## Office of Water

**Our ref :** ER20843  
**Your ref:** S09/01810

**SUBJECT: MT PIPER PLACEMENT PROJECT – LITHGOW LOCAL GOVERNMENT  
AREA (APPLICATION REFERENCE: 09\_0186)**

The NSW office of Water (NOW) has reviewed the Environmental Assessment (EA) for the Mt Piper Placement Project – Lithgow Local Government Area (Application Reference: 09\_0186).

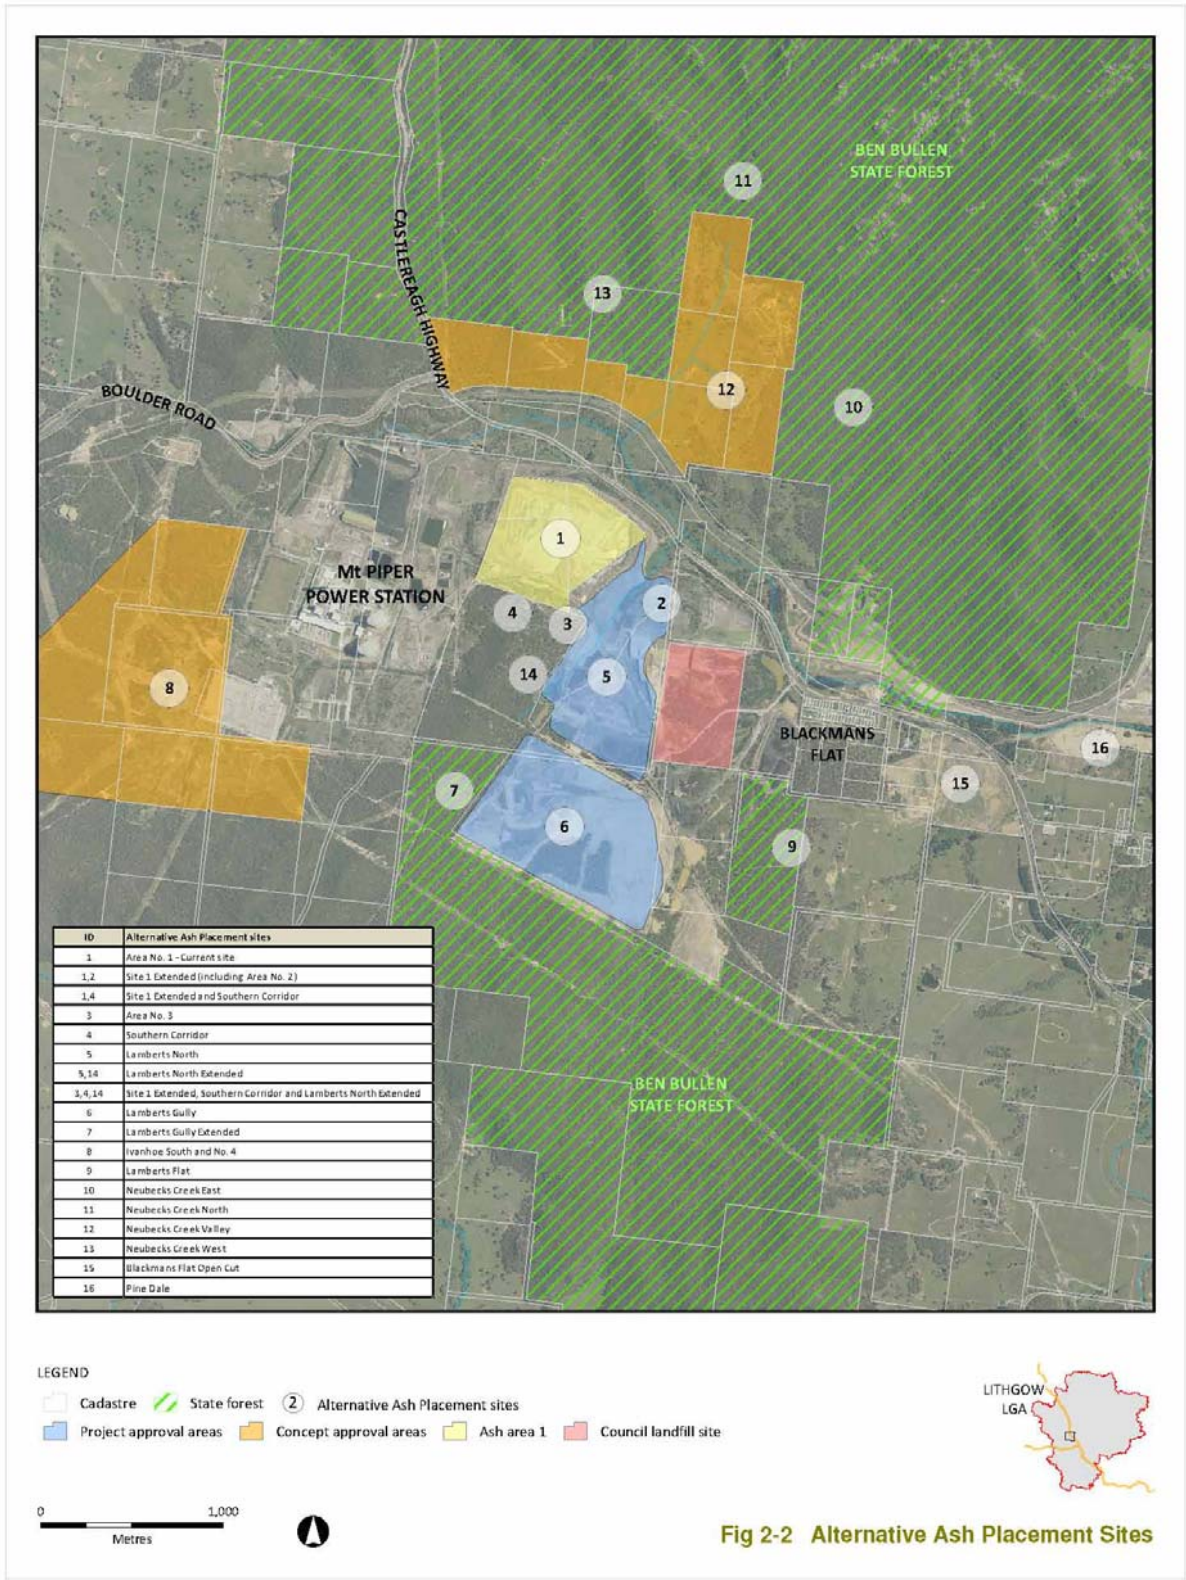
The site water balance appears to be developed on the assumption that rainfall is higher than evaporation in the Mt Piper Area and that groundwater inflows are minimal in the GCB. Due to the results presented in Figure 2-2 for rainfall/evaporation and conflict with rainfall and evaporation statements (Section 2.1), the evaporation averages developed from the Bathurst Agricultural Station and the lack of groundwater data provided (Table 2-11 – Summary of inputs and demands for data included in model). NOW have concerns about the accuracy of the site water balance model. As there has been no indication of an alternate water supply for drought contingency, NOW have provided conditions in Attachment B for a revised site water balance.

- a) The site water balance is to be revised prior project commencement with the balance model to take into account:
  - i. volumes of groundwater seepage into the GCB,

- ii. provide details on water usage for current ash disposal area and predicted water usage requirements for years 1 to 5 for the proposed ash disposal areas,
  - iii. updated evaporation calculations based upon climatic data within the Lidsdale area, and
  - iv. net evaporation from storages
  - v. net runoff generated, stored and used.
- b) Any potential additional water requirements above harvestable rights need to be identified and licences obtained under the relevant water legislation.
- c) Identify alternative water supply for drought contingency.
